RE: Peer Review of Kariong Sand and Soil Supplies Air Quality Impact Assessment Response to Submissions

Todoroski Air Sciences (TAS) has reviewed the *Kariong Sand and Soil Supplies Air Quality Assessment – RTS* prepared by Northstar Air Quality (dated 10 December 2020) on behalf of five nearby landowners of Acacia Road and Debenham Road, Somersby (Lot 3 239 Debenham Rd East, Somersby, 252 Debenham Rd East, Somersby, 242 Debenham Rd East, Somersby, 10 Acacia Rd, Somersby, 12 Acacia Rd, Somersby).

This review of the response to submissions (RTS) follows the peer review undertaken by TAS (dated 22 September 2020) of the *Kariong Sand and Soil Supplies – Proposed Development Air Quality Impact Assessment (Northstar Air Quality, 2020a)*.

SHEET NAME TIP AND SPREAD BAYS - PLAN AND SECTION

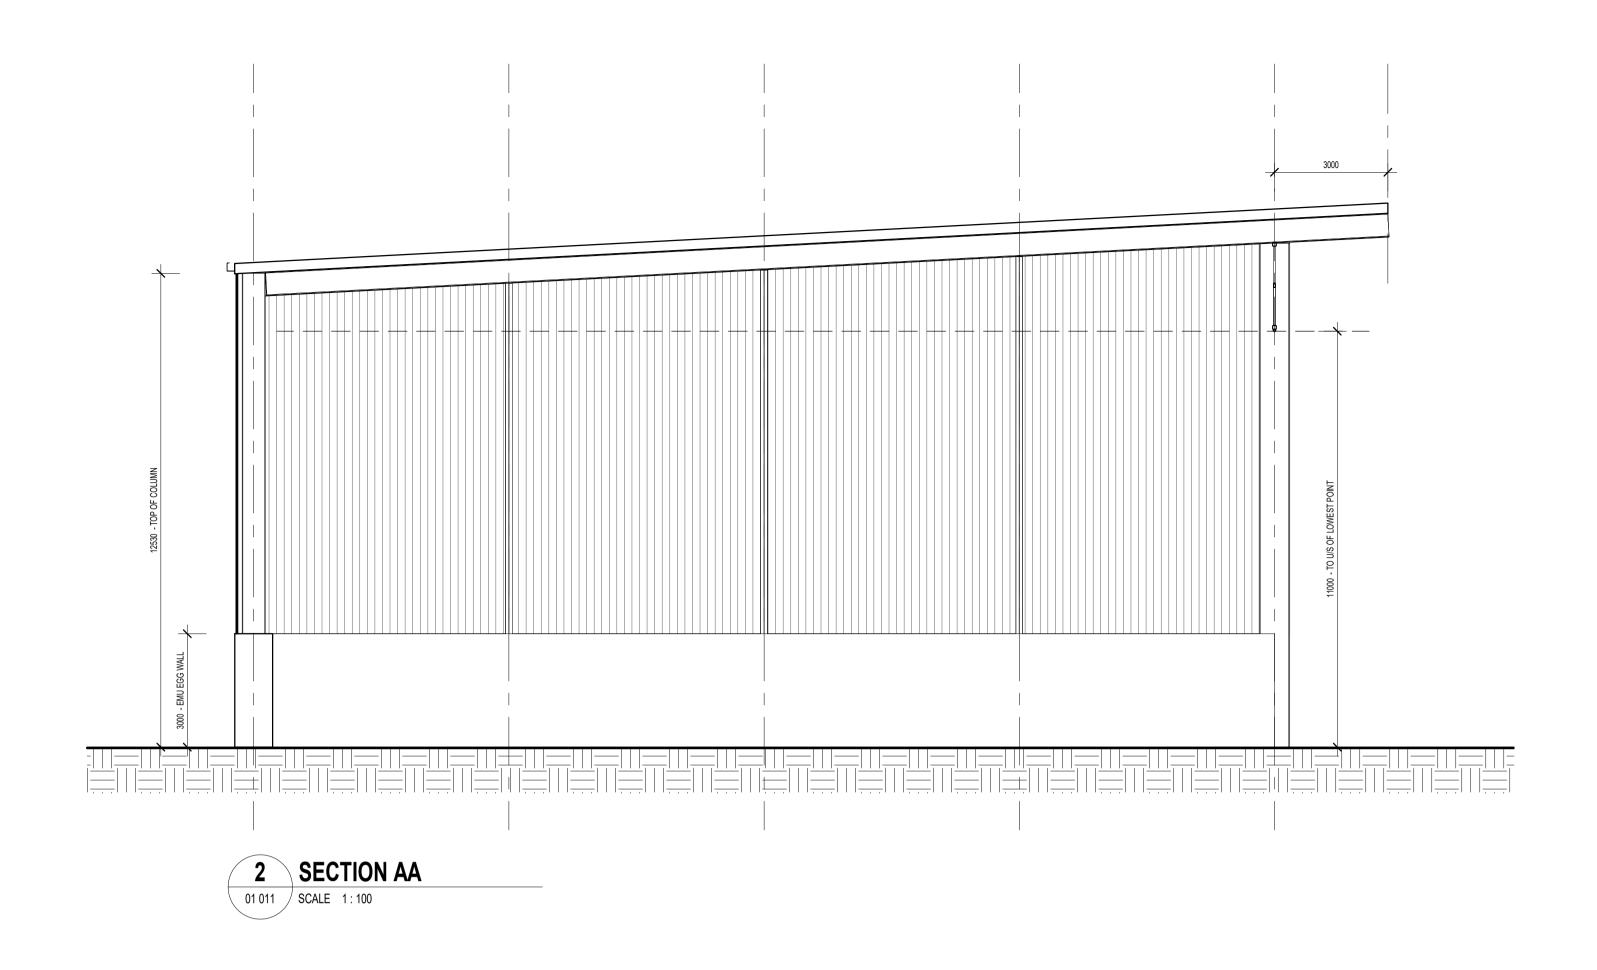
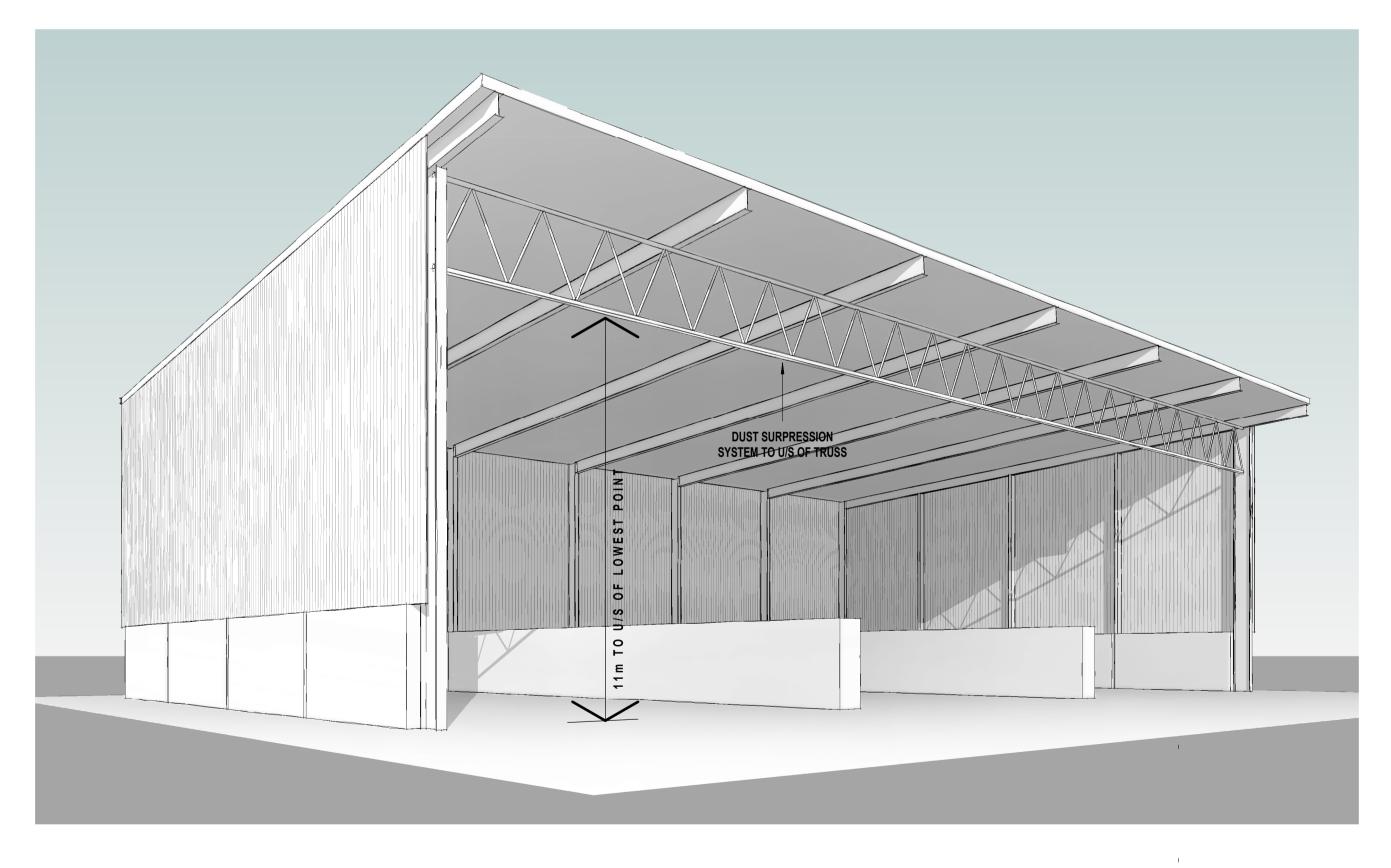
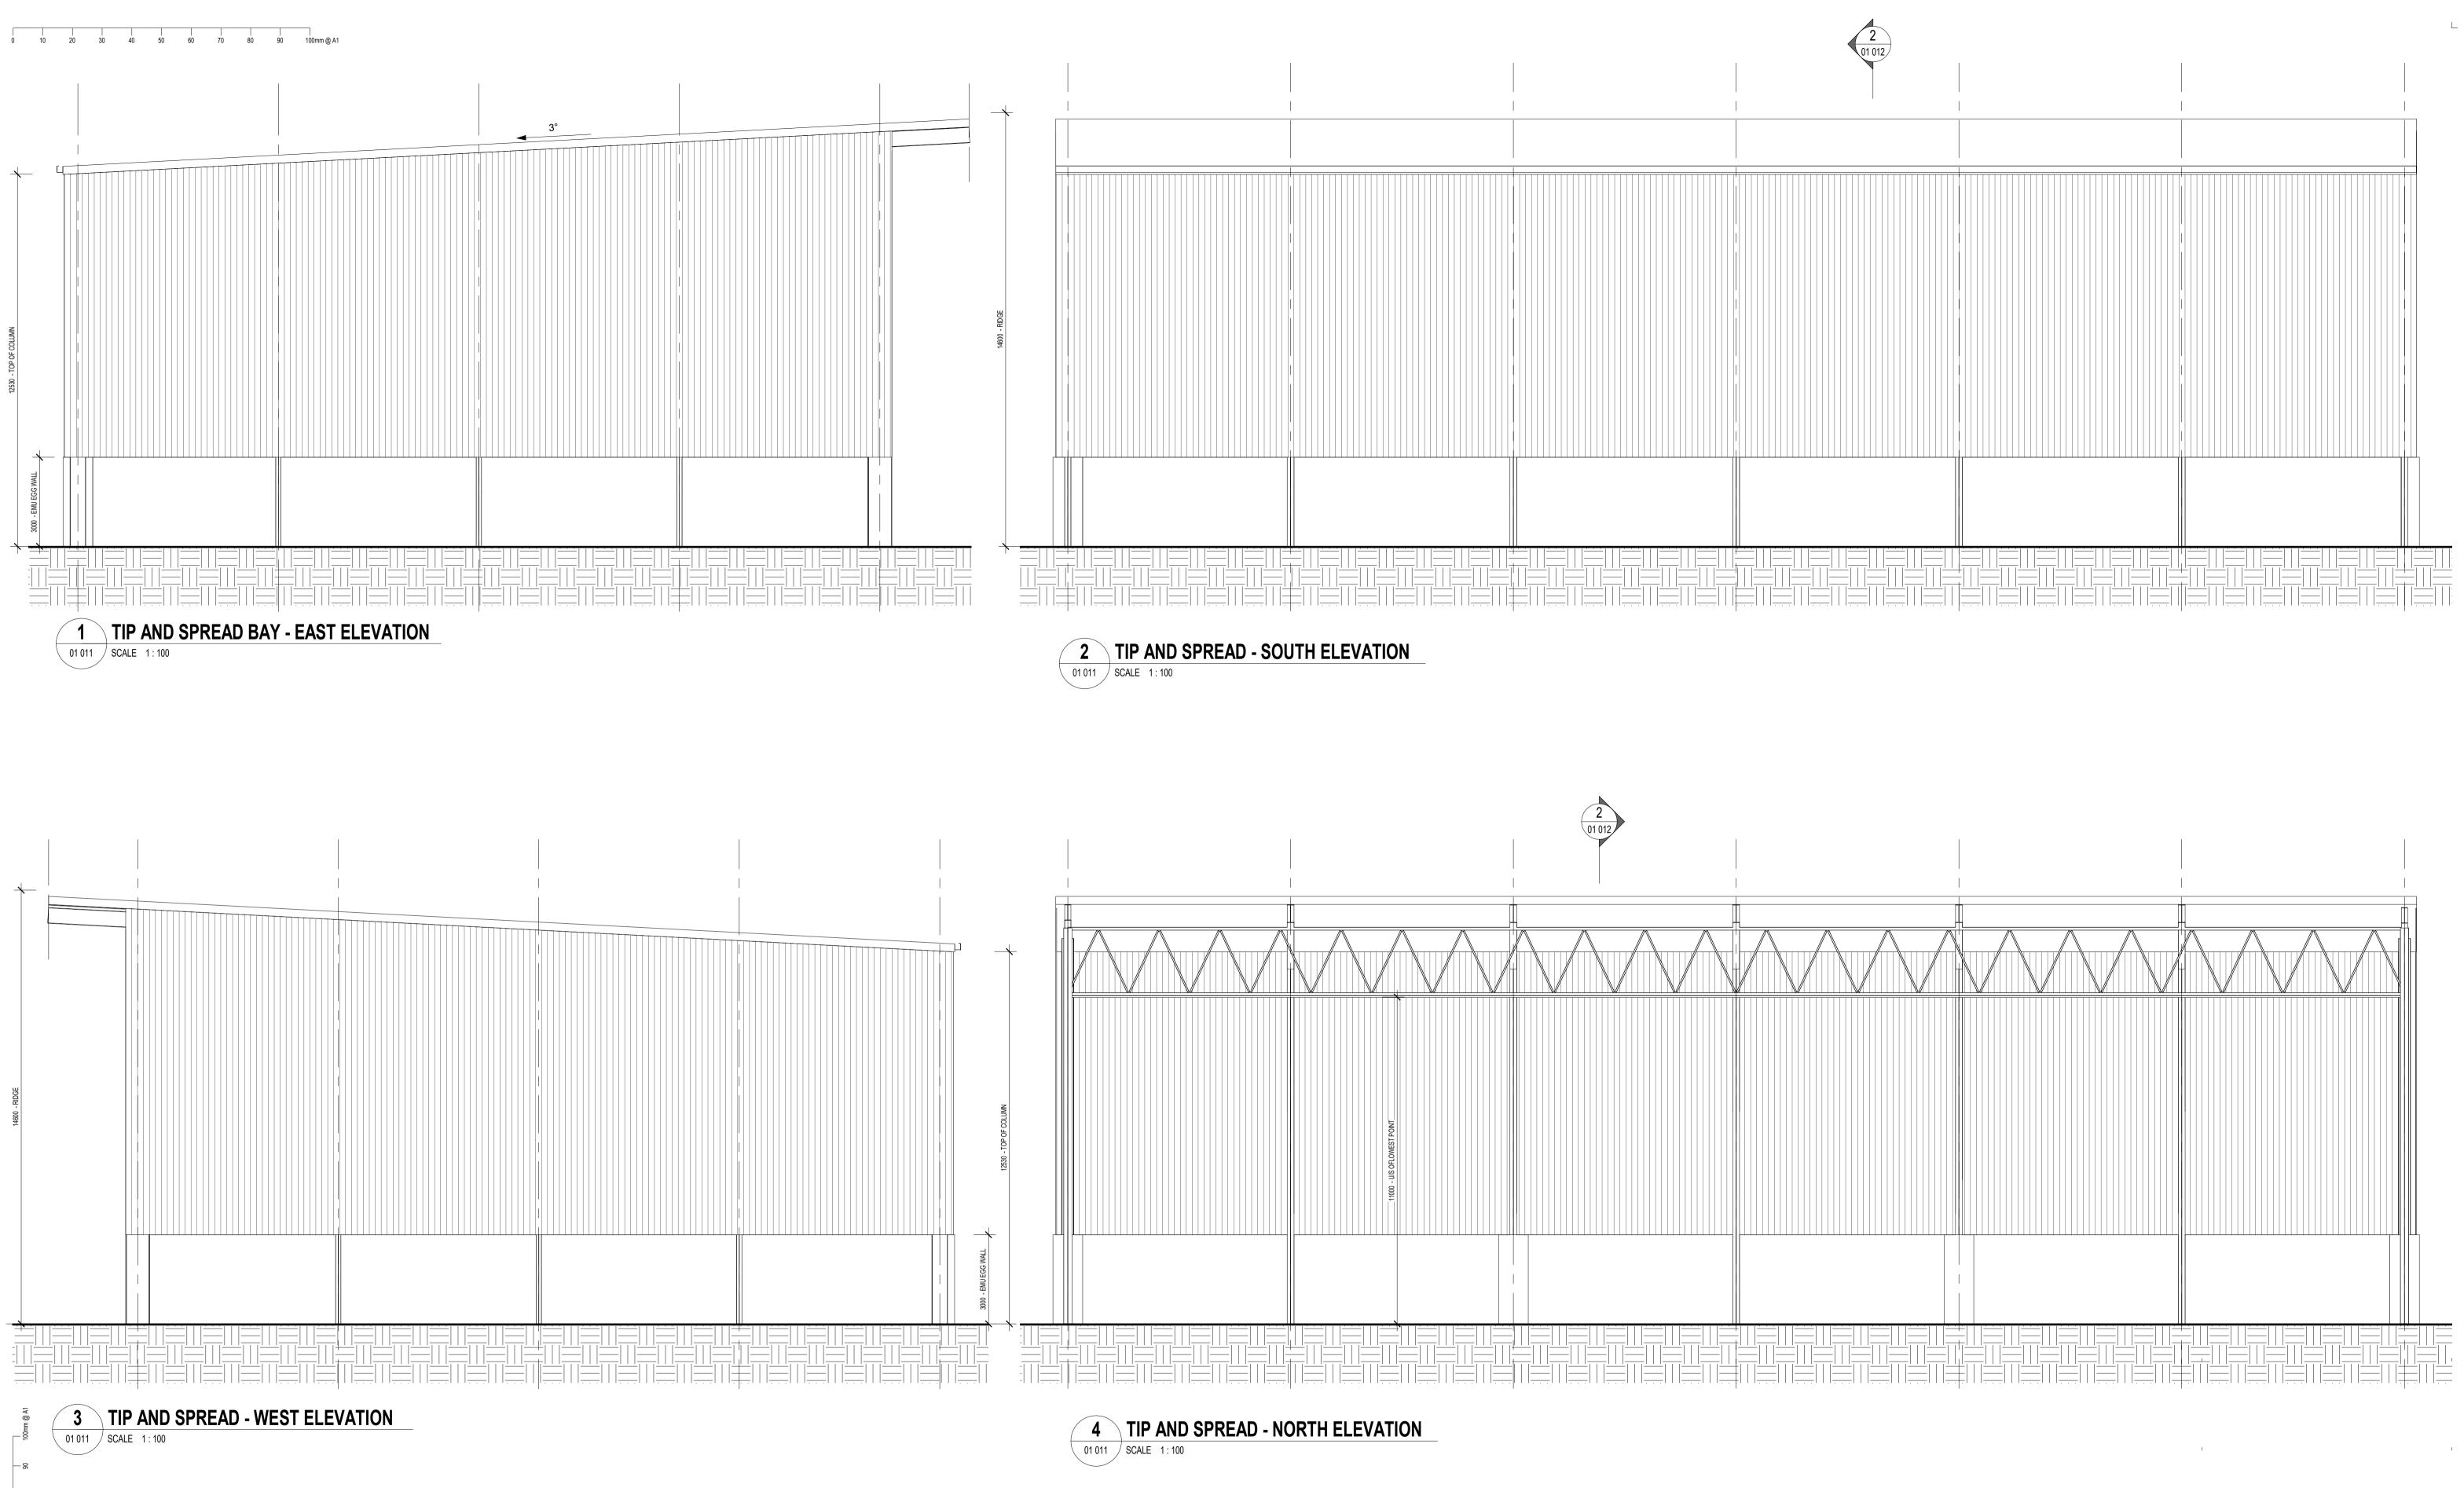
There is a doubling up of control factors in many cases, and this makes the emission implausibly low. An example is the tipping of every load in the 3-sided enclosure. Closer examination shows that this level of control (70%) is not realistic for this "enclosure", and that there would be quite limited shielding offered in this case given there are three short walled adjacent tipping bays, and the frontal opening spans all three and is very wide. The mechanism by which a 3-sided enclosure provides benefit is that the stockpile is hemmed in on three sides (i.e. piled up the sides of 3 walls), giving it a much smaller surface area than the same material pile out in the open. Yet, the entire purpose of the receivals bay in this case is to take the entire pile and spread it thinly on the ground, greatly increasing the dust emissions relative to any normal pile. This will result in more emissions overall than a normal uncontrolled pile (not a total 85% reduction as has been assumed).

The RTS has missed the point of the comments. It is not claimed that emissions controls cannot be multiplicative. The issue raised predominately concerns the design of the facility and also the management of materials at the receival bays and questions the veracity of the control factors applied to adequately represent the likely emissions of dust from this source.

Further description of the proposed design of the three-sided enclosures and spread out materials surface area has not been provided in the RTS to justify the adoption of the control factors that would be achievable due to the relatively poor design of the facility, and the proposed manner of handling materials at the facility.

The present industry standard control measure for the material spreading and related activities is to conduct these fully indoors with fixed water sprays onto the unloading pad and/or direct hand watering as per currently proposed local industry practice (e.g. similar to the proposed Bingo facility across the road, which is referred to in the AQIA).

This is incorrect. Emission controls factors are multiplicative, and the application of multiple (but different) controls on one source is appropriate and standard practice and has been adopted. Full discussion is provided in response to issues 2 and 3 above.

b) *Waste tipping and spreading building:* All waste delivered to the site is via vehicles accessing the site and travelling over a fully sealed asphalt pavement through to the tip and spread building. No vehicle access is required over the recycled concrete pavement (which may generate dust). This building has three fully enclosed sides, and is supported by a full ceiling mounted dust suppression system. This process will enable the detection and removal of non-compliant waste materials, that could otherwise impact on recycling operations and product quality.
